Department of Primary Industries

QR National Train Support Facility (MP07_0171) Response to exhibition of Environmental Assessment

Comment by Fisheries NSW

Comment by NSW Office of Water

Figure 3: Project layout

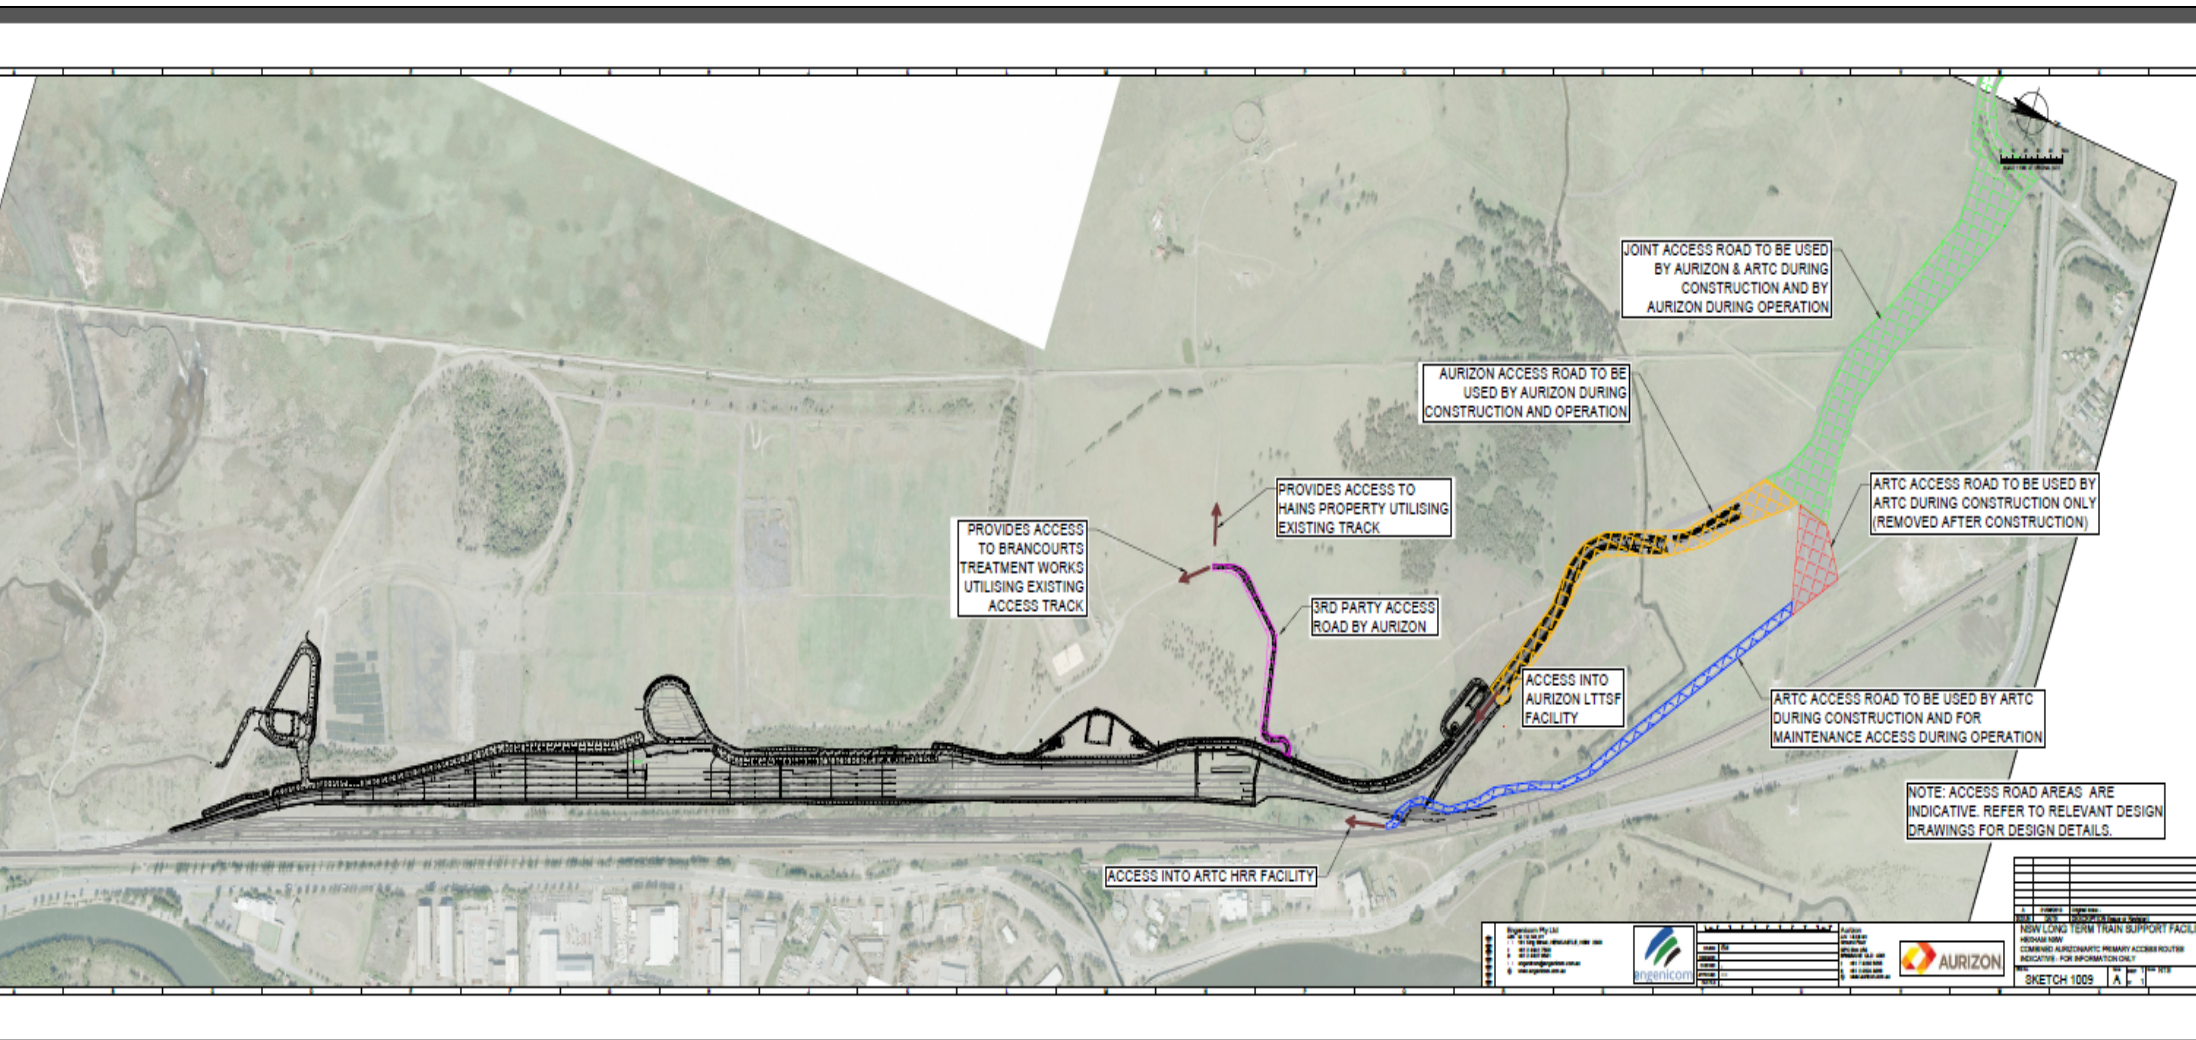
- (iii) the scale of the diagrams and lack of final design detail of the rail layout at the southern crossover makes it difficult to determine the potential impacts of the development on the creek that drains the southern saltmarsh area. If the new crossover requires the construction of culverts or a bridge over the creek, Fisheries NSW should be involved in discussions in relation to blockage of fish passage and flow management to avoid detrimental impacts on the upstream aquatic habitats and fauna.

- (1) Any management plans for the offset site in the southern section of the proposal to include a commitment to manage appropriately the downstream waterway that drains this location to ensure the continued tidal flushing of the site, including maintenance of the culverts under the railway corridor to the Hunter River.
- (2) If the design of the rail layout at the southern crossover requires the construction of culverts or a bridge over the creek at this location, the design is to be developed in consultation with Fisheries NSW and avoid any detrimental impact on the upstream aquatic habitats and fauna by making adequate provision for fish passage and water flow management.

Figure 7b: The stormwater management system, southern section

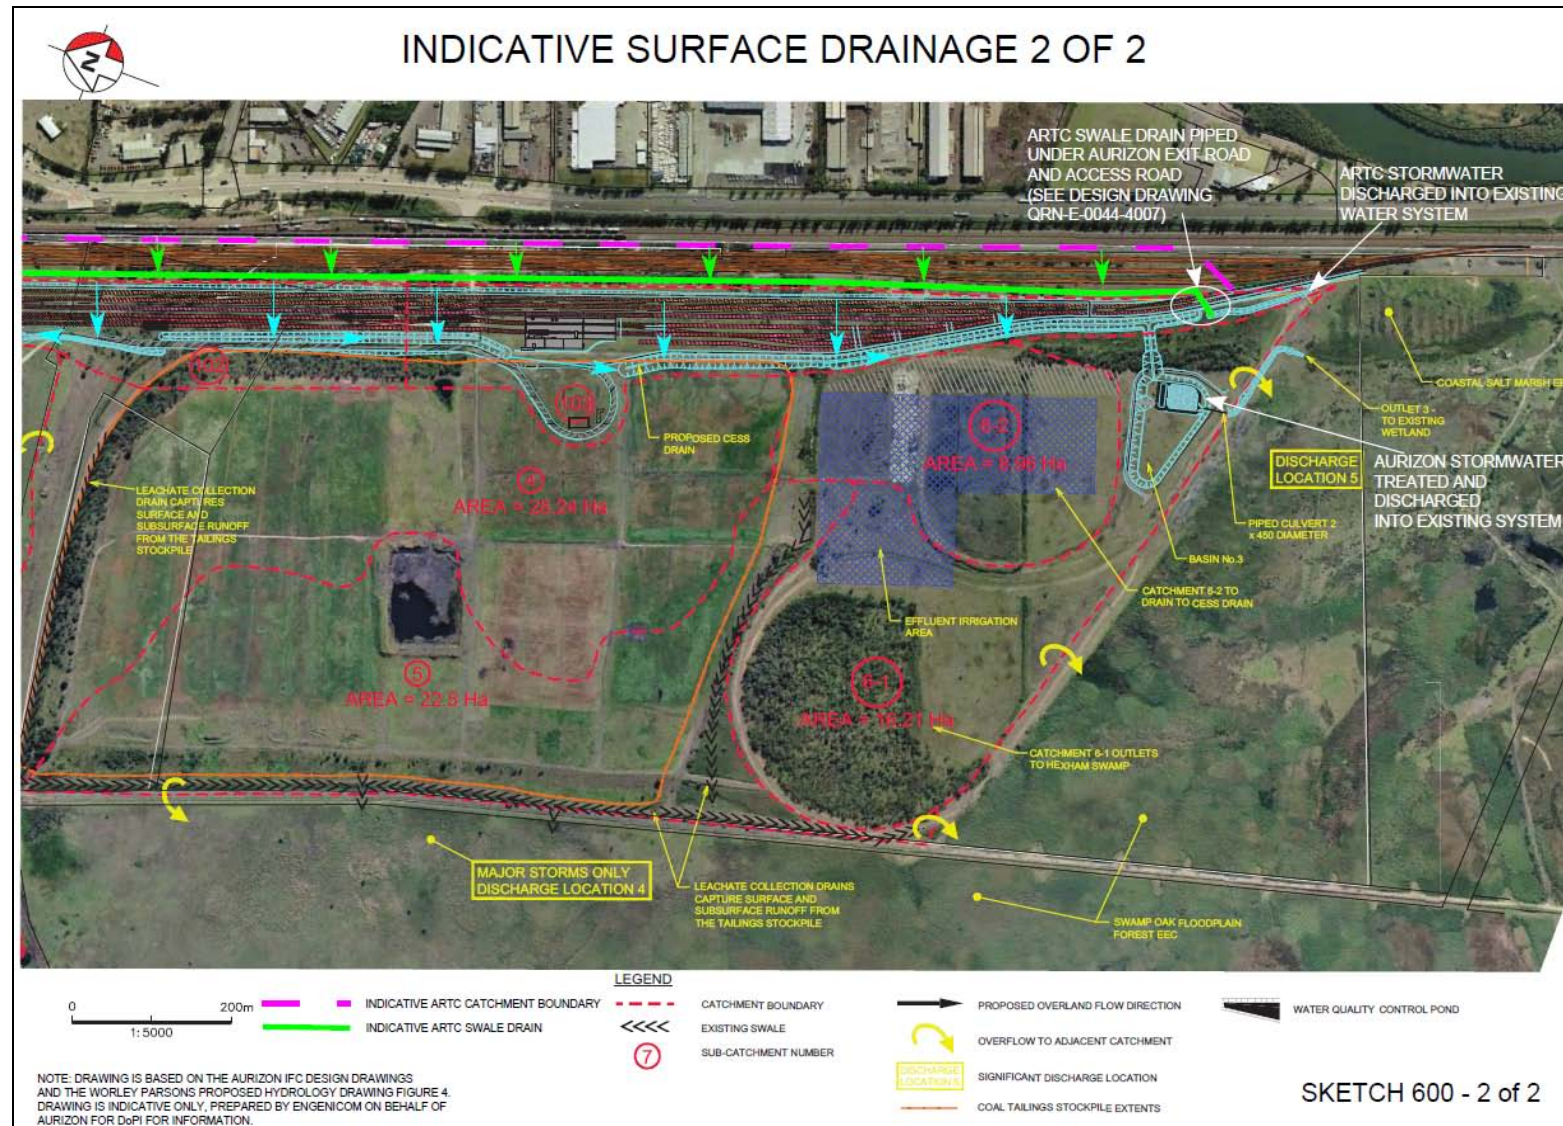
- (i) impacts generally are limited to isolated SEPP14 wetland area and previously impacted landscapes. There is the potential for some impacts on adjoining saltmarsh areas due to discharge of stormwater to the southern end of the site. This area adjoins Smithy's, an area that has been slowly rehabilitated to ensure saltwater intrusion to return saltmarsh and fish habitat to the area. There will be some benefit as the existing area of wetland/saltmarsh complex will be placed under a management regime as an environmental offset.

- (ii) the assessment of the impact on the saltmarsh community in the southern areas is understated. The potential impact of increasing freshwater inputs into the saltmarsh community is likely to have long-term effects. The increases in freshwater gradually leach the salt from the soils, allowing the introduction of less salt tolerant species over a long period of time. Any changes to the flushing of this area with saline (tidal) water will result in a degradation of the site that is above and beyond the impacts mentioned by the proponent. Consequently, the proponent should include a commitment to manage appropriately the downstream waterway that drains this location to ensure the continued tidal flushing of the site.
